An  
Bord  
Pleanála

## Inspector's Report ADDENDUM ABP-310312-21

Construct up to 8 no. wind turbines with a tip height of up to 185 metres and all associated foundations and hardstanding areas. An Environmental Impact Assessment Report (EIAR) and a Natura Impact Statement (NIS) have been prepared in respect of the proposed development.

Townlands of Dernacart Forest Upper & Forest Lower , Co. Laois

| SHEET TYPICAL TURBINE DETAILS | Date 20.09.19 | Project number P1892 | Scale (@ A1-) AS SHOWN |

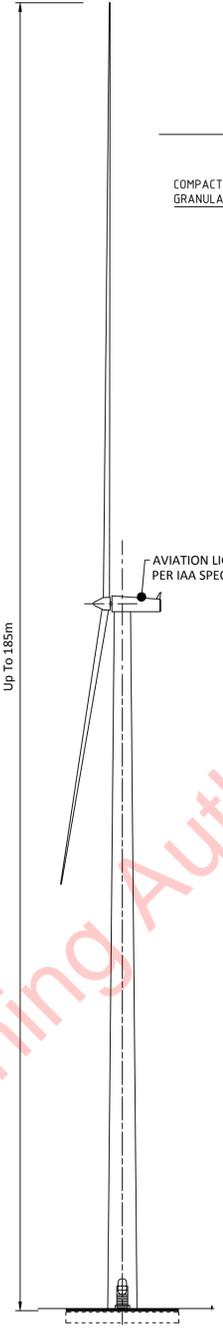
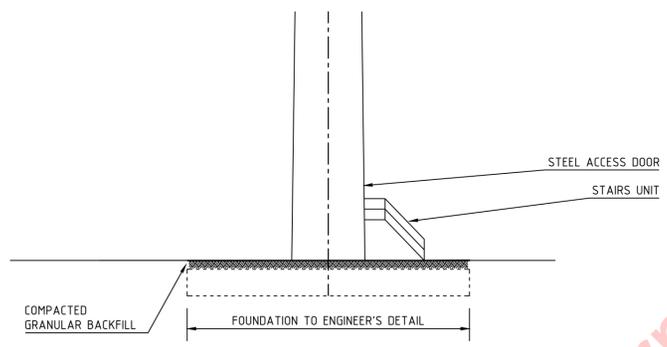
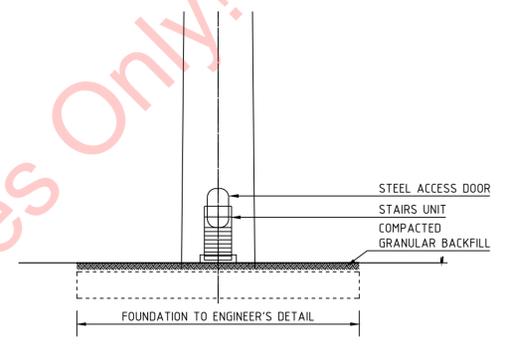
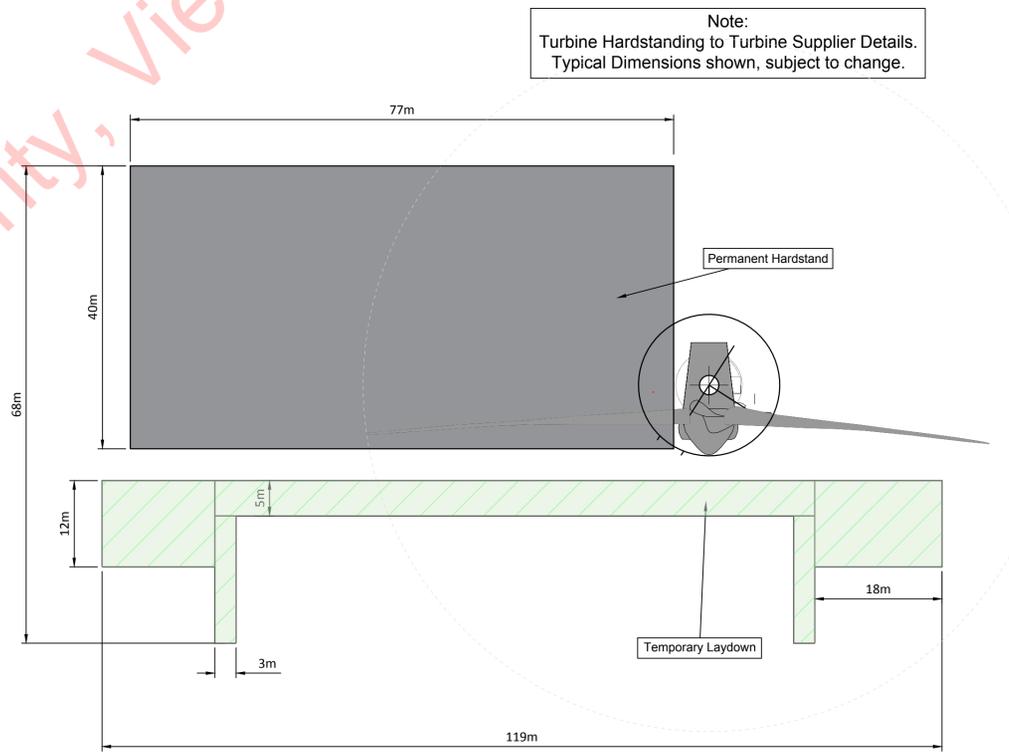
- It is noted that the development description as set out the statutory notices refers to a tip height of up to 185 metres. There is no reference to hub height or rotor diameter in the statutory notices to enable the Board to determine the appeal. Please confirm the nature and extent of the development for which permission is sought, including dimensions of the proposed turbines relating to hub height, tip height and rotor diameter, by reference to plans and particulars which describe the works to which the application relates, in compliance with the relevant provisions of the Planning and Development Regulations 2001, as amended.

- If the development for which permission is sought incorporates a range of options, please indicate clearly in the application documentation the detail of all such options and confirm that each option (or a single option if clarified by reference to item 1 above) has been fully assessed within the application documentation including within the Environmental Impact Assessment Report and/or Natura Impact Statement as appropriate.

- Foundation dimensions referred to in response to the third-party submissions will be 20 meters (width and length) and 2 metres deep.
  - In relation to the proposed turbines the following measurements apply:

- Tip height – 185m
    - Hub Height 100m
    - Rotor diameter – 170m
    - Plan enclosed labelled P1892-0400-0001 includes all dimensions.
  - It is confirmed that the turbine number and foundation dimensions have been assessed within the EIAR submitted with the application.

- 3.1.3. I have reviewed the proposed turbine dimensions and details provided in the context of the EIAR submitted with the application and am satisfied that the details submitted have been adequately considered and assessed within the EIAR and no further assessment is required in this regard. The decrease in hub height, given that the overall height of the turbines remains unchanged, will not be immediately obvious when viewed in the context of the wind development from the surrounding landscape
